Our reference: P-354804-H3G2
Contact: Kathryn Saunders
Telephone: (02) 4732 8567

Aspect Industrial Estate Modification 2 – SSD 10448 Proposed Mod-2

Thank you for providing Penrith City Council with the opportunity to comment on the proposed modification (MOD 2) to State Significant Development Application no. SSD-10448, known as Aspect Industrial Estate.

Civil Engineers and Project Managers	at&l Level 7, 153 Walker Street North Sydney NSW 2060 ABN 96 130 882 405 Tel: 02 9439 1777 Fax: 02 9923 1055 www.atl.net.au info@atl.net.au
Status	FOR APPROVAL NOT TO BE USED FOR CONSTRUCTION
Project - Drawing No.	18-596-C2143
Issue	B

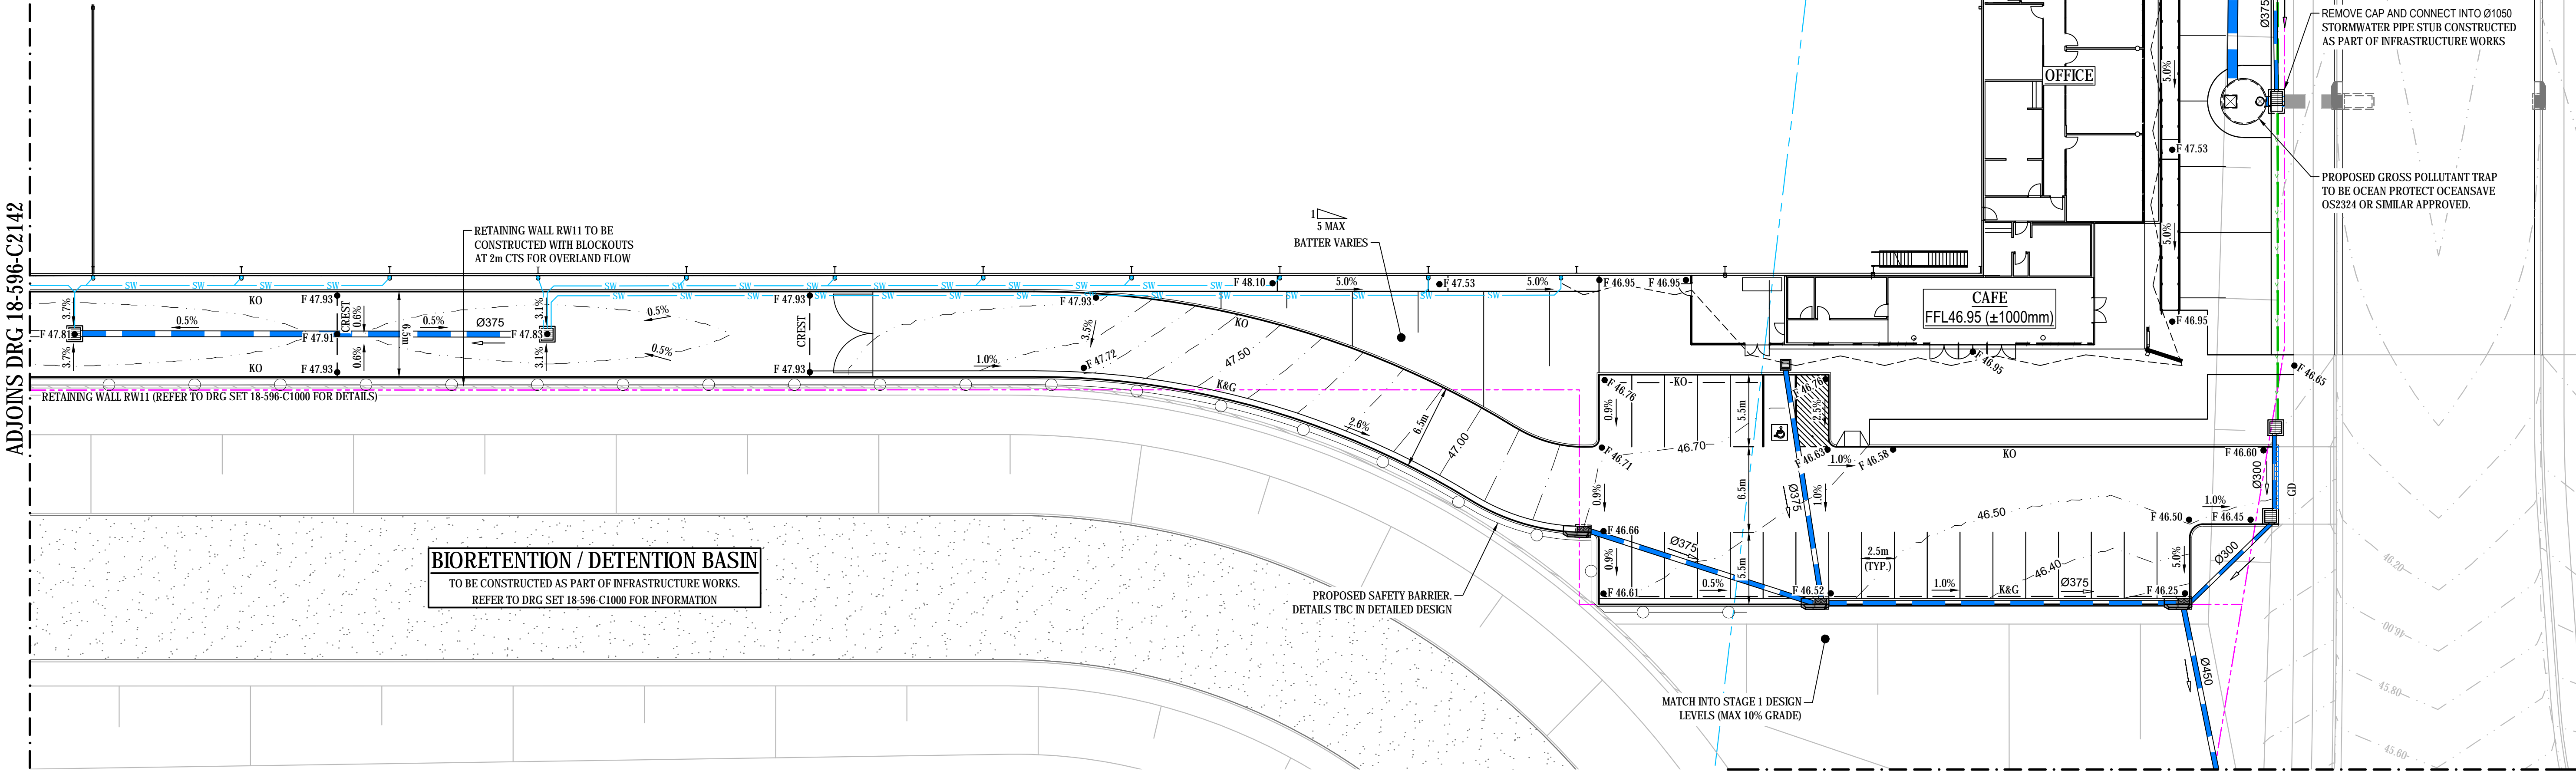
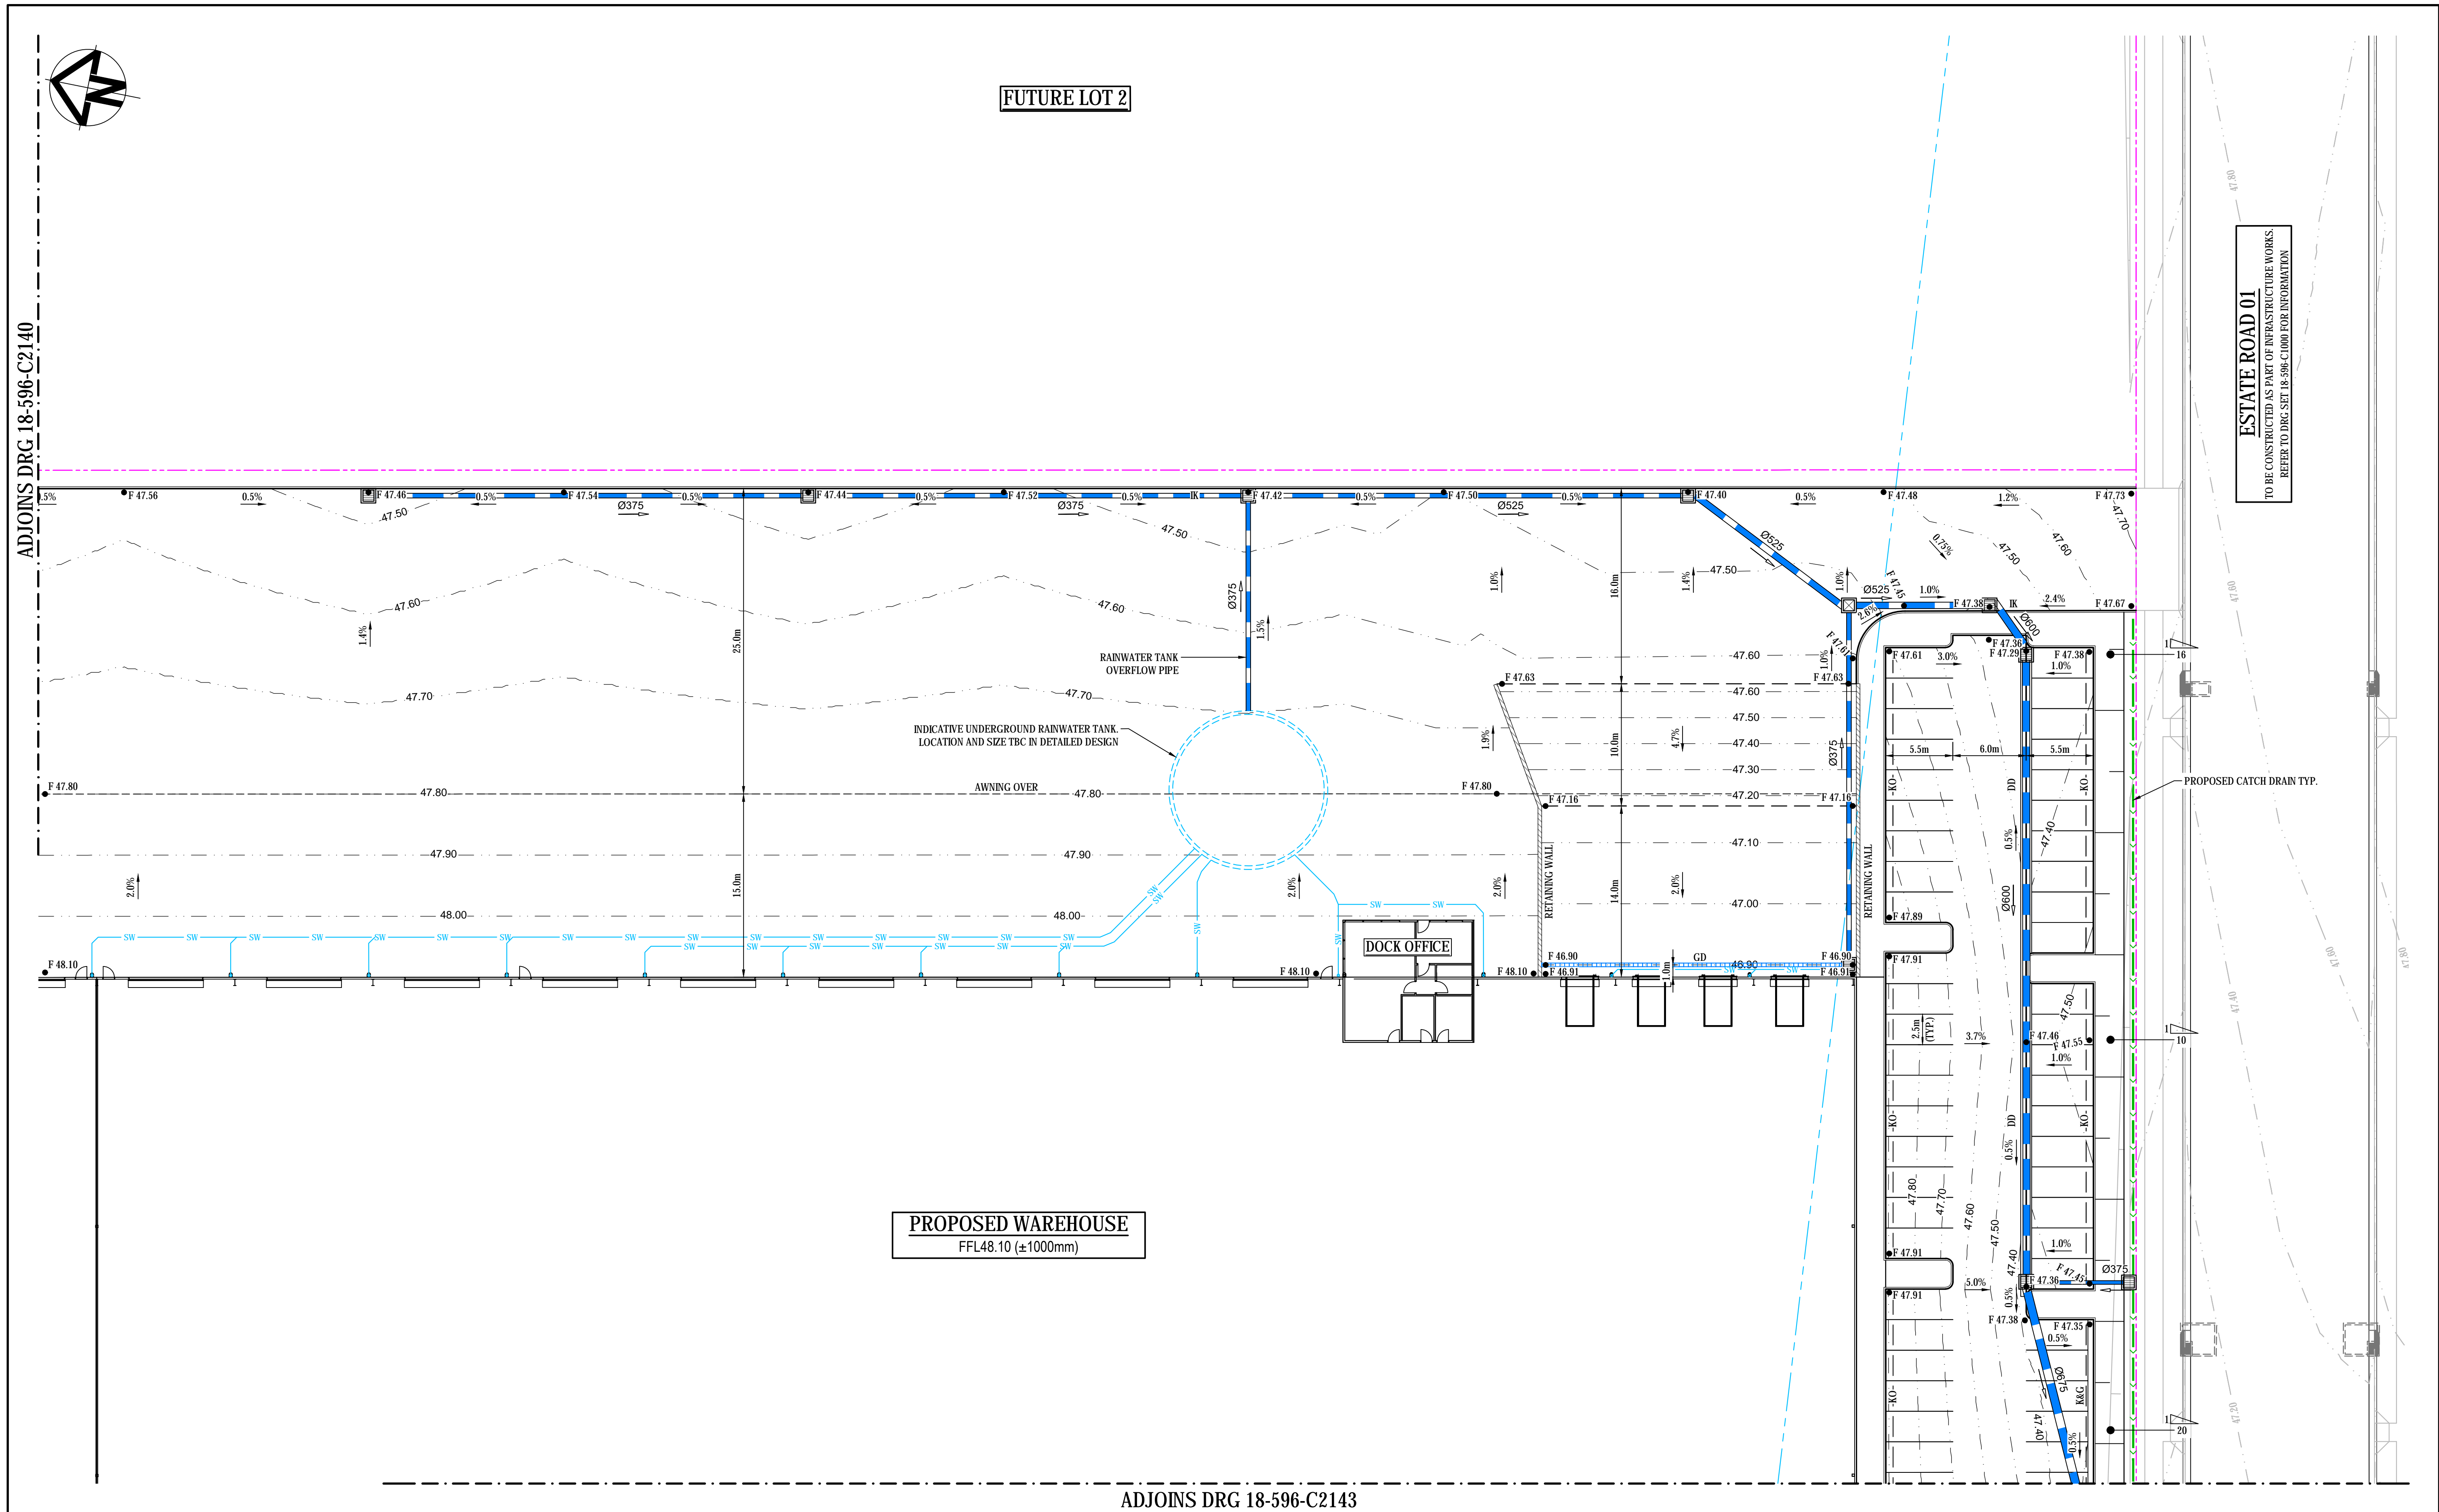
Previously provided section through this area have been removed from the civil and landscape sets.

Notwithstanding the above, trees are not achievable in the selected location upon review of the sections and owing to the location of the palisade fencing, the retaining wall, and the super awning above.

Figure 9: Civil plans indicating no space for canopy tree planting (refer 18-596-C2143 issue I)

Canopy trees previously approved in the Estate are significantly reduced by the amended plans which is not supported by Council. The resultant presentation of Warehouse 1 to Mamre Road is to be addressed and improved. The warehouse footprint is to be reduced to enable the provision of canopy trees, shrubs and along this elevation.
